Re: US ELECTRIC
301 California St. SE
Approval of Permanent Certificate of Occupancy (C.O.)
Engineer's Stamp dated 08/22/2004 (K-18/D92)
Certification dated 06/28/2005

**Re: US Electric, Acoma Rd SE, Grading and Drainage Plan
Engineer's Stamp dated 8-22-04 (K18-D92)**

Re: US Electric, Acoma SE, Traffic Circulation Layout
Architect's Stamp dated 8-17-04 (K18-D92)

SITE PLAN

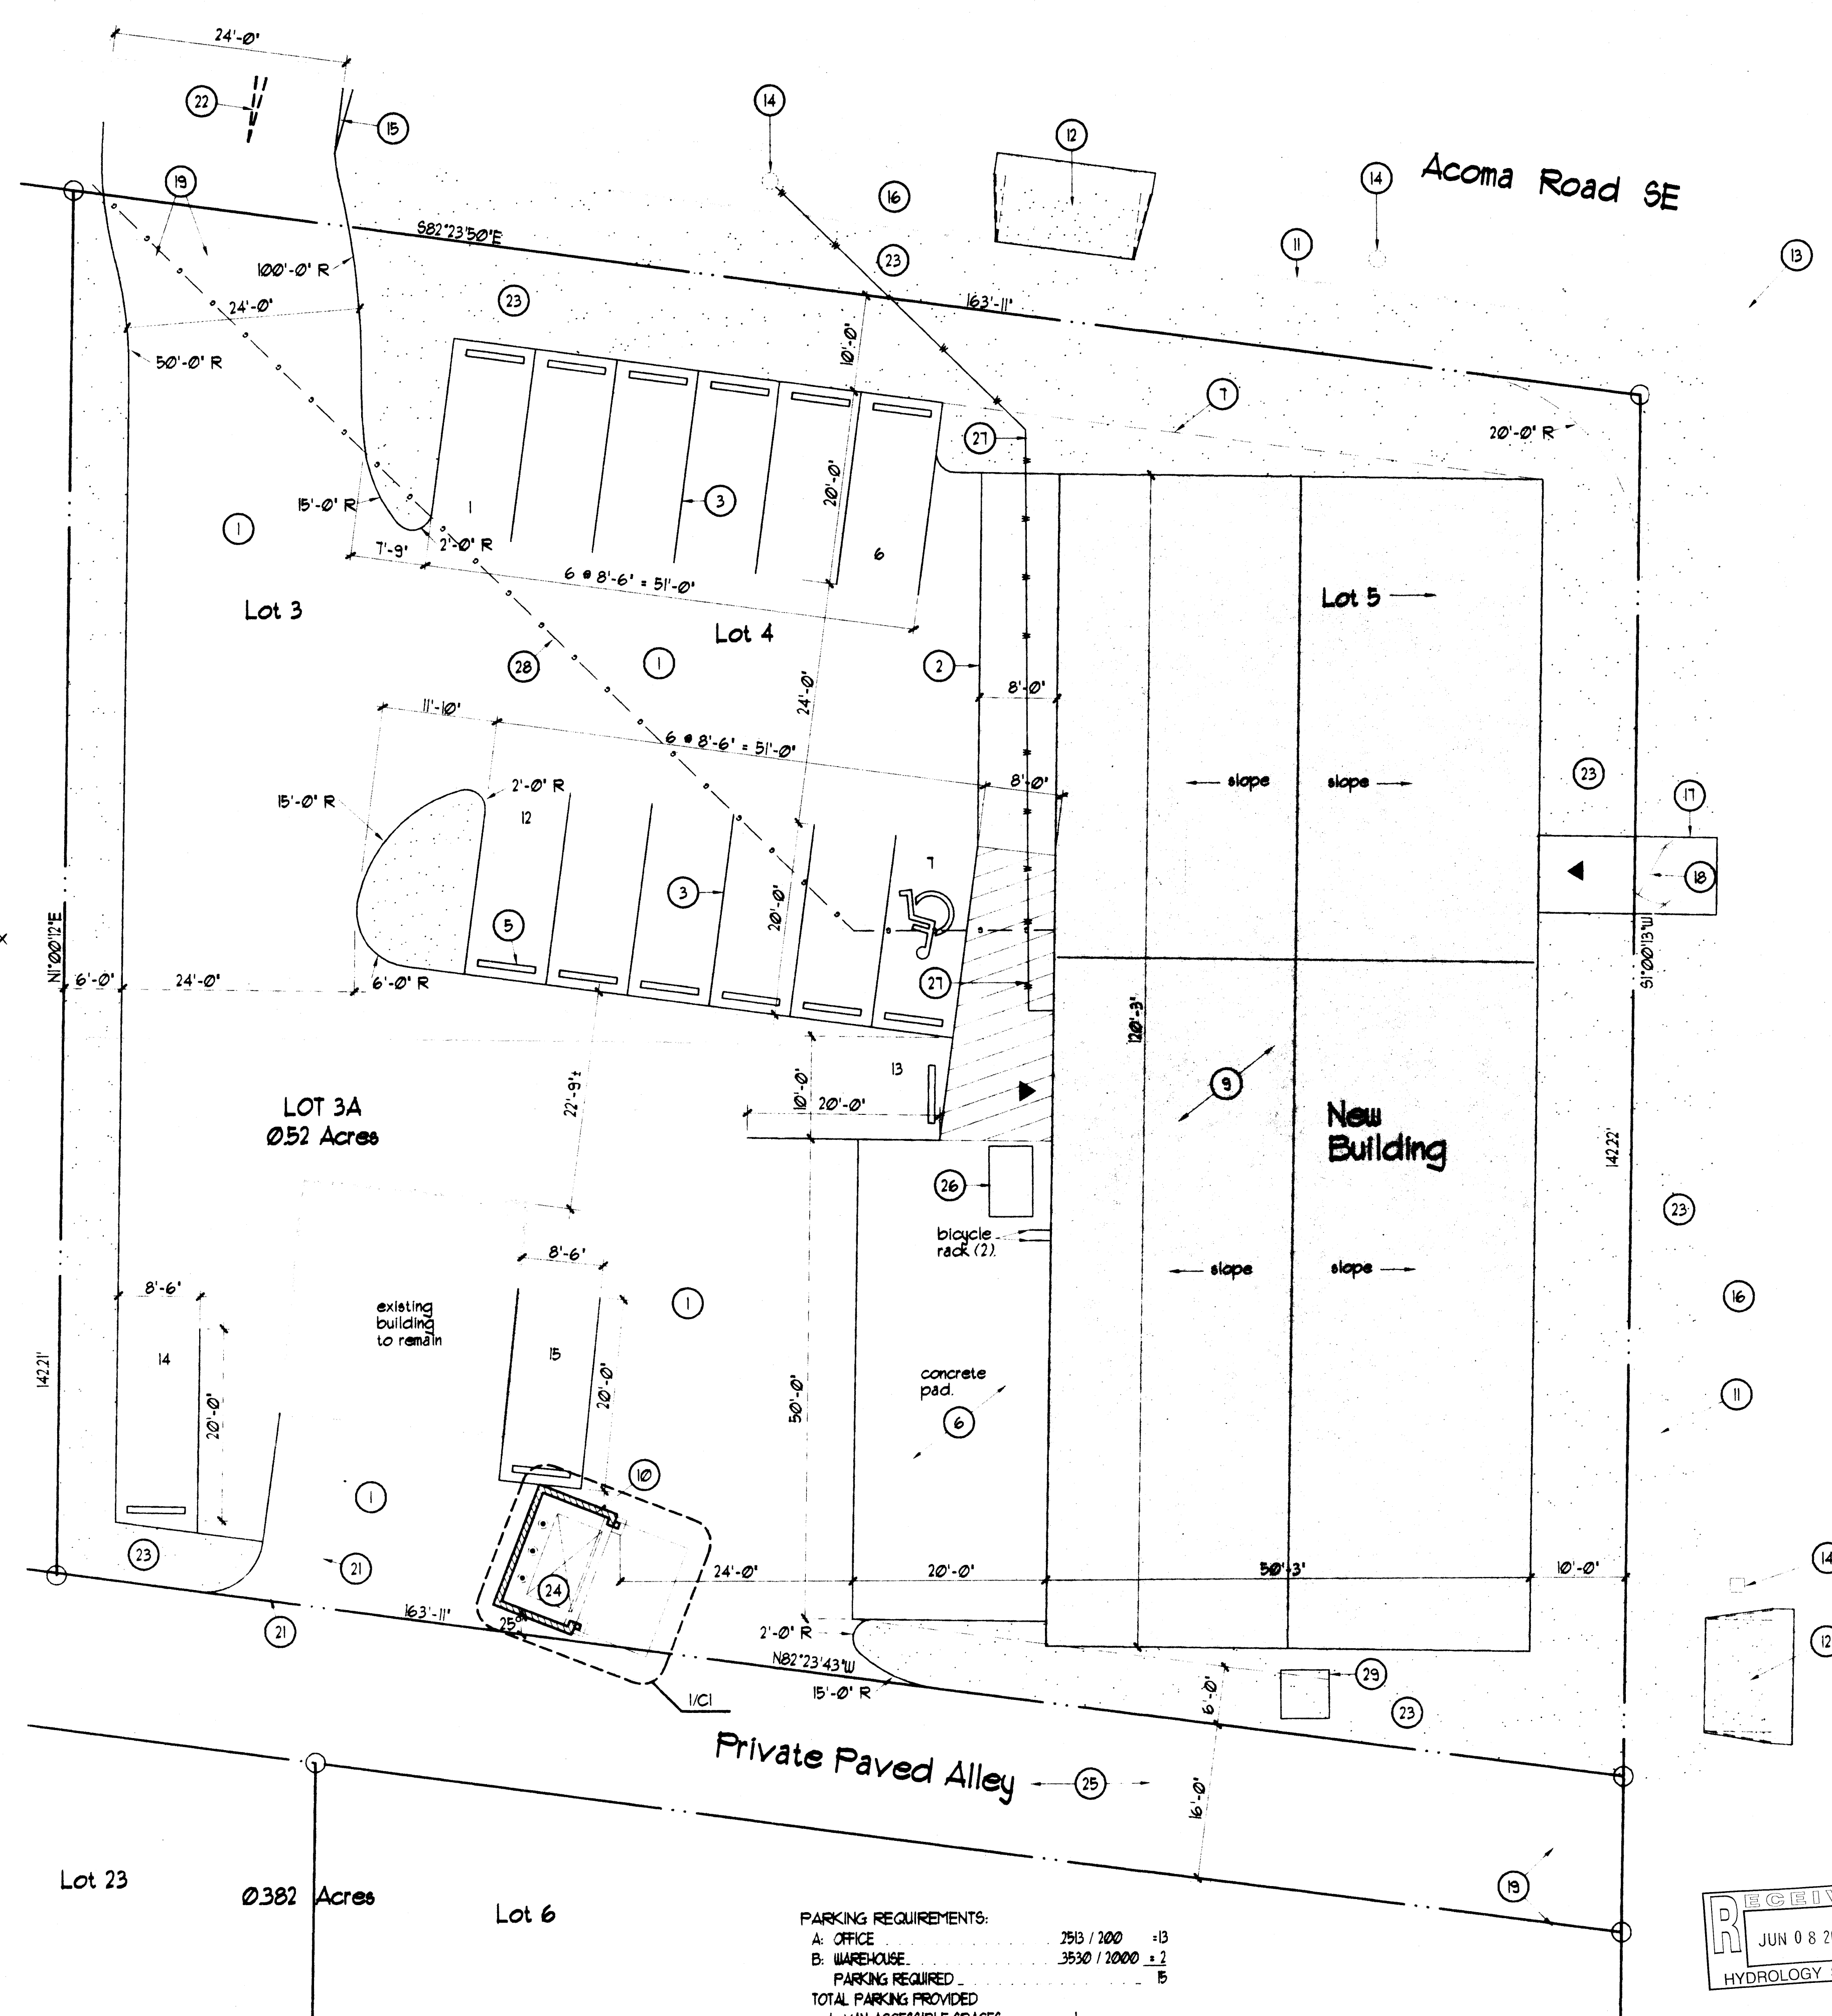
1. Provide details for the proposed curb cut, noting that the curb cut should be a minimum of 24 feet wide. These details should be provided on the Traffic Circulation Layout, not just on the Civil sheets.
2. The existing curb cut called out in note 12 must be closed.
3. Please refer to all applicable city standards.
4. Is the paved alley shown a public alley? If so, why is it gated?
5. All aisles should be a minimum of 24 feet in width.
6. Please show a vicinity map on the Traffic Circulation Layout.
7. List the number of parking spaces required by the zoning code as well as the proposed number of parking spaces.
8. Is this site accessible through the alley? If so, please note that the minimum end island radius for passenger vehicles is 15 feet.
